Reference	Respondent	Question	Response
<b>1 - Miscellaneous and General</b>			
MG1.1.22	The Applicant Portsmouth City Council	Does Portsmouth City Council accept that it would take responsibility for the maintenance of the proposed landscape planting at the landfall after 5 years of establishment, as suggested at 1.6.4.1 of the Outline Landscape and Biodiversity Strategy [APP-506]?	<p>Portsmouth City Council (PCC) would wish to contain control of all relevant parts of our land. Whether maintenance responsibility should sensibly pass to PCC would be dependent on whether that landscaping was on land retained by PCC or on land that has passed into the applicant's control or ownership. If the proposed landscaping was on land that has passed into the applicant's ownership PCC would not expect to be burdened with the maintenance of it but would expect an appropriate requirement to approve a landscaping scheme and require the applicant to maintain it to fulfil its amenity and other purposes.</p> <p>Where landscaping is proposed on land retained by PCC the Council would accept the responsibility for maintenance after 5 years of establishment but an appropriate commuted sum to be paid by th

CONTINUED ON SHEET 2

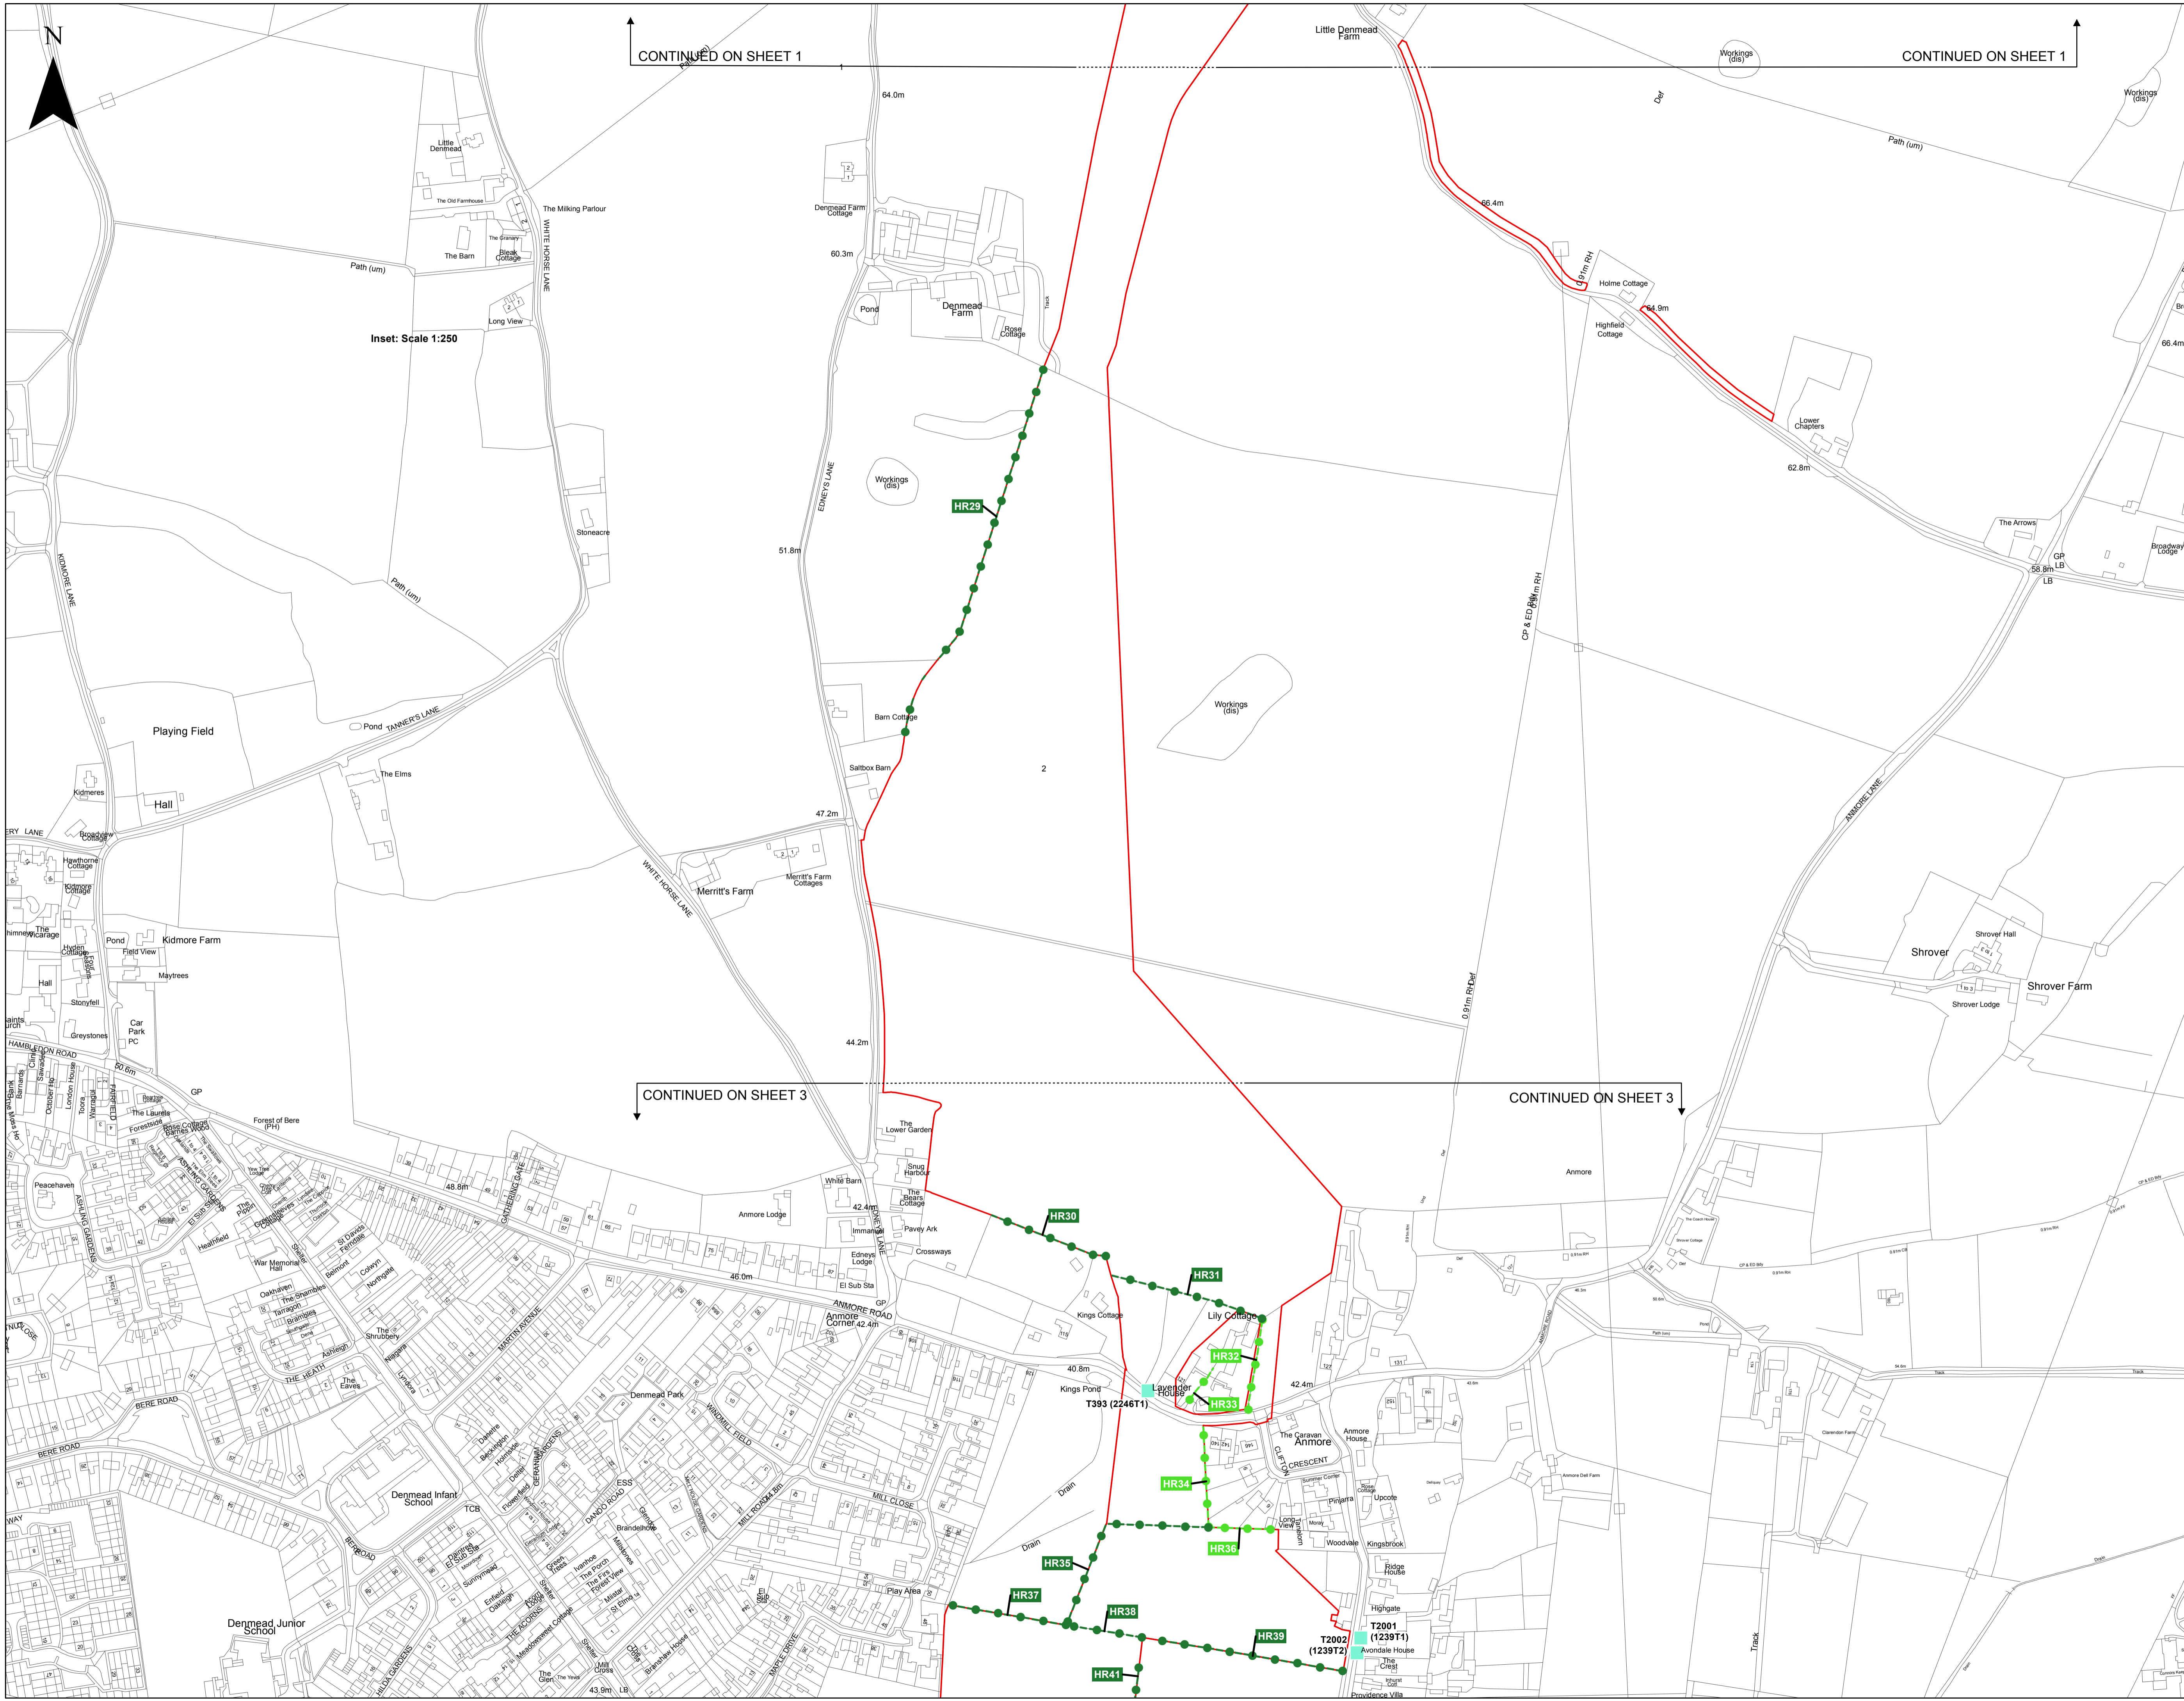
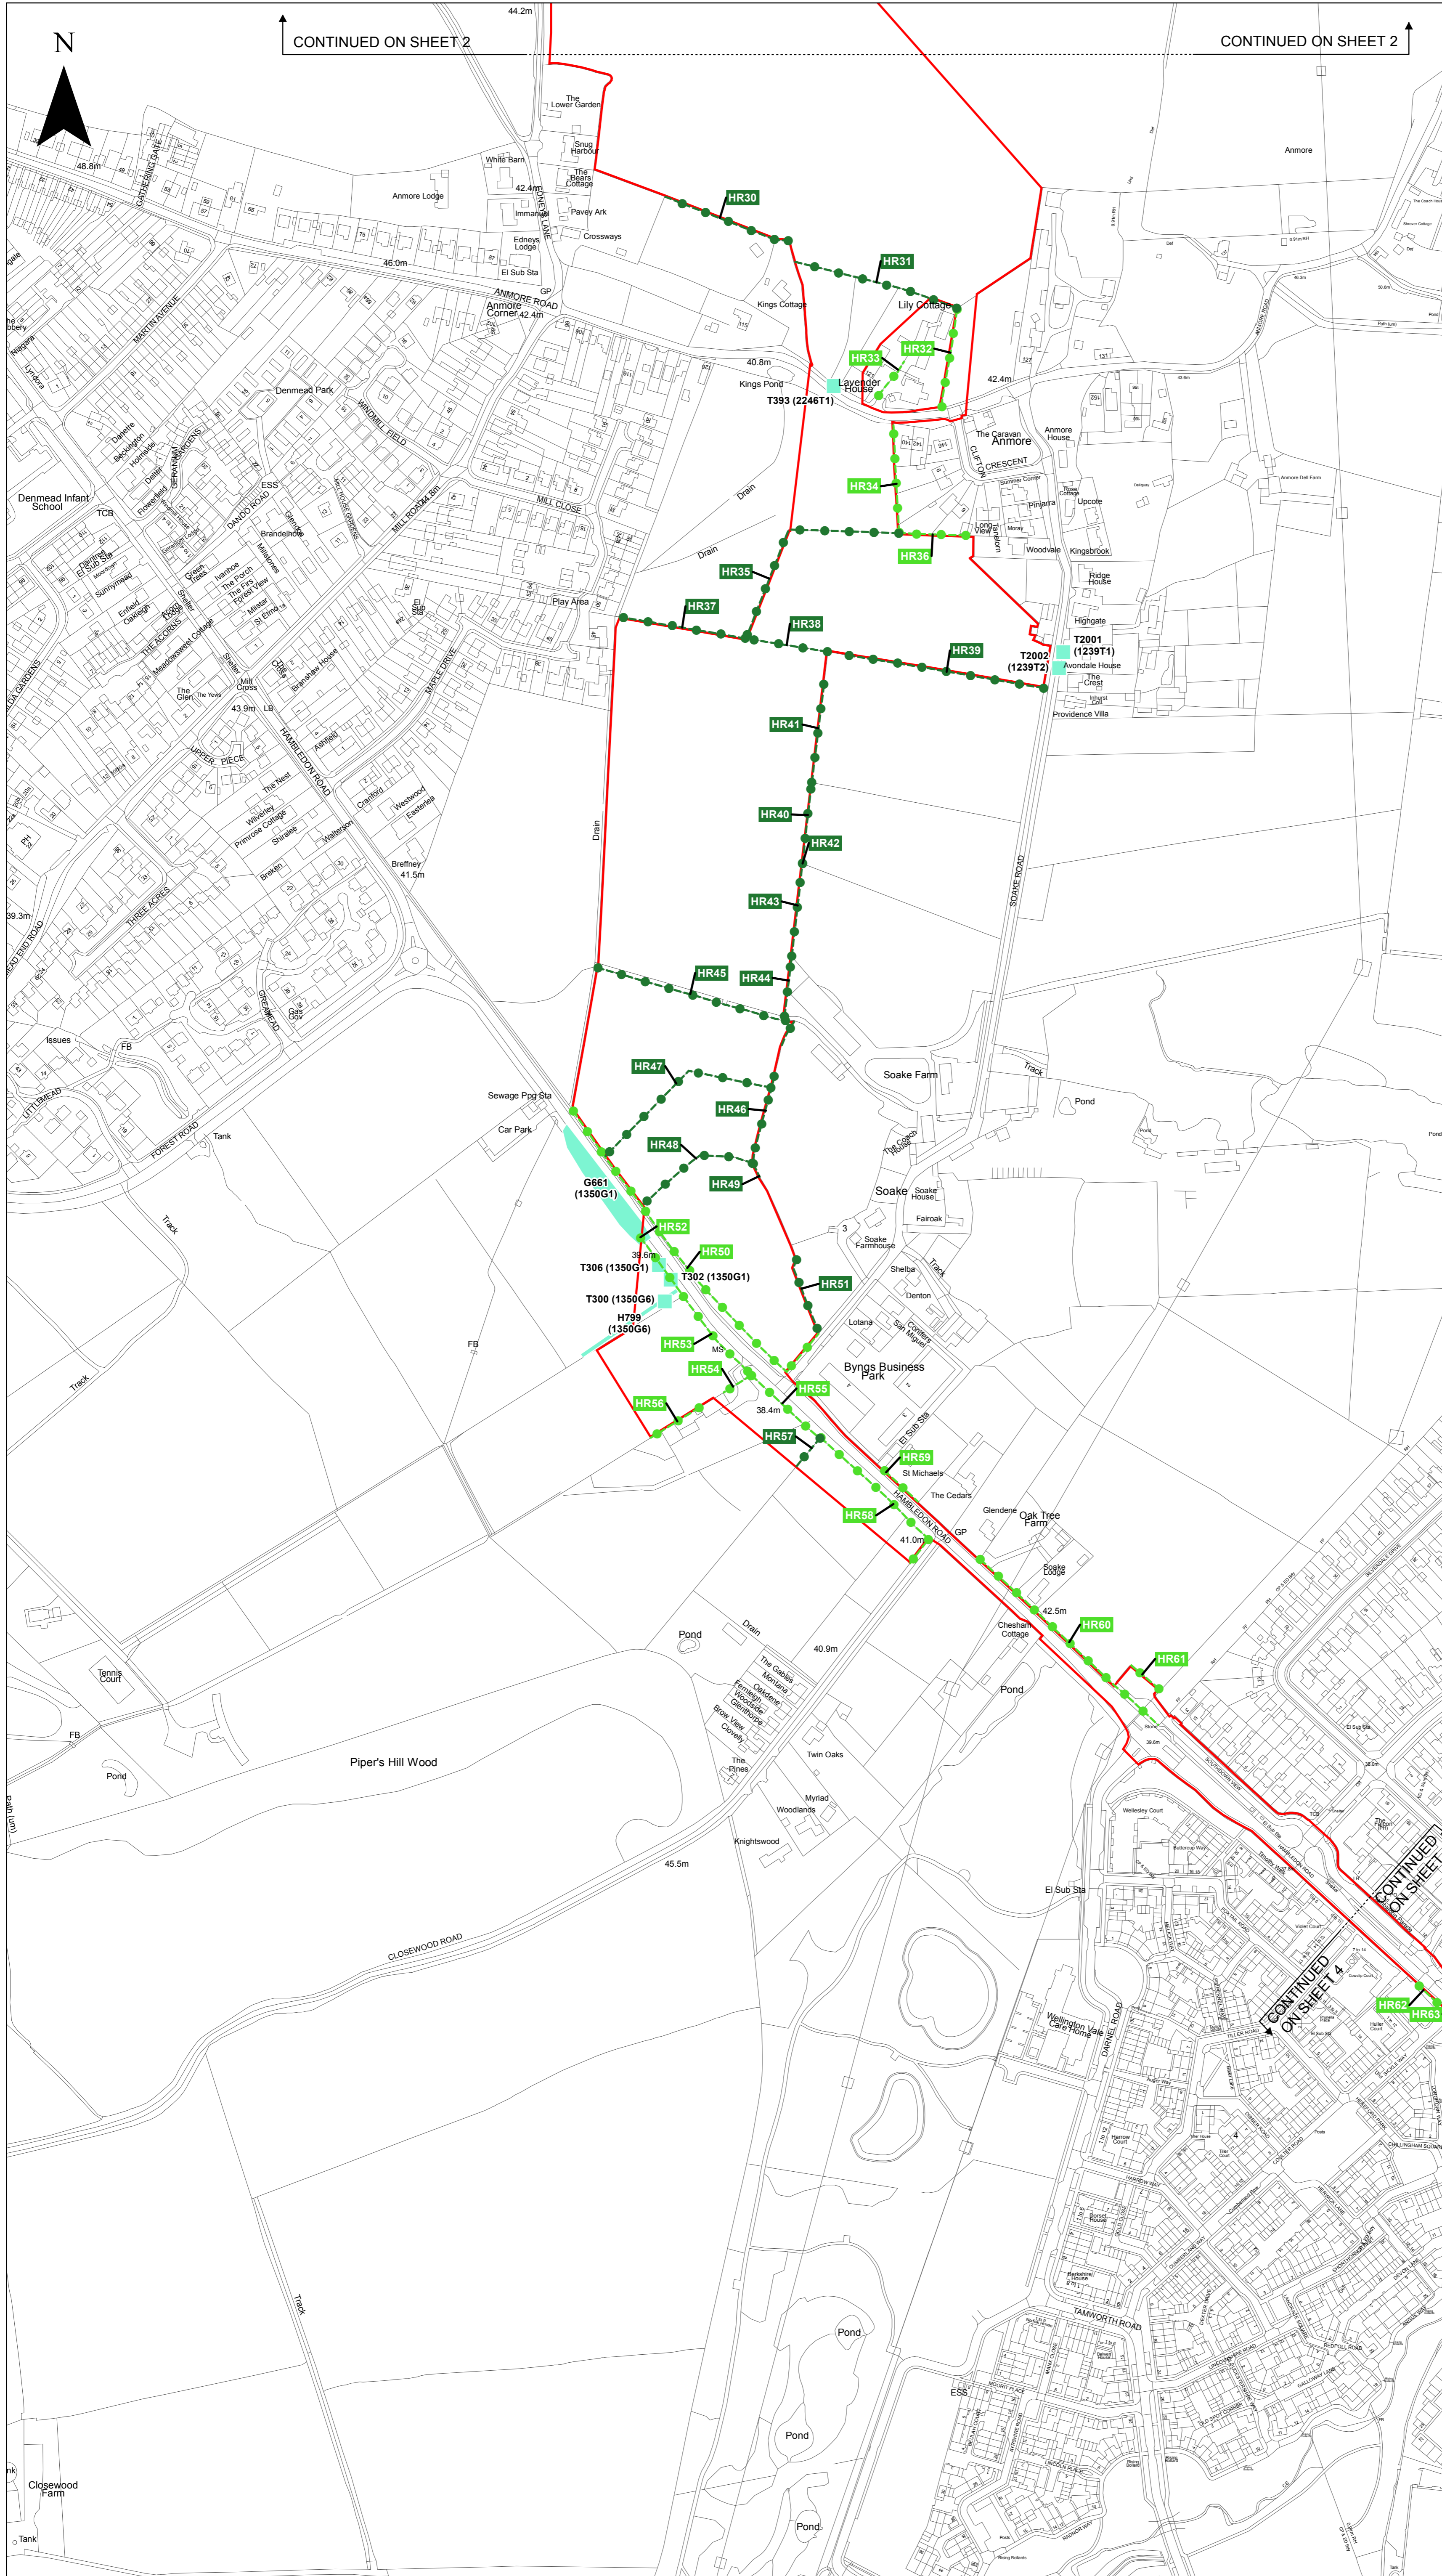
The Applicant seeks powers over any tree in the Order limits rather than providing a schedule (as per model provisions and as is usual in other recently made DCOs). Schedule 11 of the dDCO [APP-019] (TPO trees) only lists 'potential removal' and 'indicative works to be carried out'. How can this be specific enough to understand the impact of the Proposed Development on trees? If this remains unchanged, should the ExA in weighing the benefits and disbenefits of the Proposed Development therefore assume the loss all of the trees within the Order limits during construction and throughout the lifetime of the Proposed Development, given that 42(2)(b) of the dDCO [APP-018] removes any duty to replace lost trees?	<p>All trees to be impacted upon must be individually identified and work proposals specified in a detailed schedule.</p> <p>If this remains unchanged, the ExA must in weighing the benefits and disbenefits of the Proposed Development assume the loss all of the trees within the Order limits during construction and throughout the lifetime of the Proposed Development, given that the proposal at 42(2)(b) of the dDCO [APP-018] removes any duty to replace lost trees?</p> <p>The potential for unmitigated loss of amenity and eco system services provided by the city's trees is huge.</p> <p>The breadth of article 41 is unacceptable and displays a lack of understanding of how local authorities manage their trees, approaching the matter through a misguidedly legalistic lens. Even then, as highlighted, Schedule 11 only engages with TPO protected trees at a disappointingly high level. The applicant may seek to argue the need for operational flexibility justifies the "potential" removals listed in Schedule 11 or the wording of Articles 41 and 42, but without any further requirement to obtain permission it must be assumed that arts 41(1) and 42(1) will result in the felling of all trees if it is commercially expedient to the undertaker. In the case of 41(1) this would occur without obliging the applicant to have regard to the amenity or other value of any tree, no matter how mature or otherwise noteworthy.</p> <p>A phased approach (such as that seen in relation to archaeology and with particular sensitivity to site clearance works falling within Onshore Site Preparation Works) could be taken for the local planning authority to approve any felling or works to trees located on land in which PCC has a legal interest, and confirm precisely which trees are not intended to be felled or subject to works. Further approval from the local planning authority should be sought to confirm that other such trees shall not be felled or worked upon (without any deeming provisions) following commencement. Such approvals for non-TPO trees should empower the local planning authority to be able to enforce appropriate replacement trees.</p>

Reference	Respondent	Question	Response
			<p>Given the requested exemption from re-planting obligations, the oversight of the local planning authority is especially important to ensure that the undertaker is accountable for its actions in relation to trees. The apparent disregard for trees as protected public assets gives PCC serious concern about whether they retain the relevant technical skills and understanding of balancing the public interest to make appropriate decisions about works to trees. The undertaker's powers should be curtailed in relation to trees and subject to local planning authority approval in relation to all trees on land in which PCC has a legal interest. It is noted that the Thanet DCO, Article 34, only granted the undertaker the power to fell or lop only those trees made subject to a TPO after July 2017, being a year before the application was accepted for examination.</p>
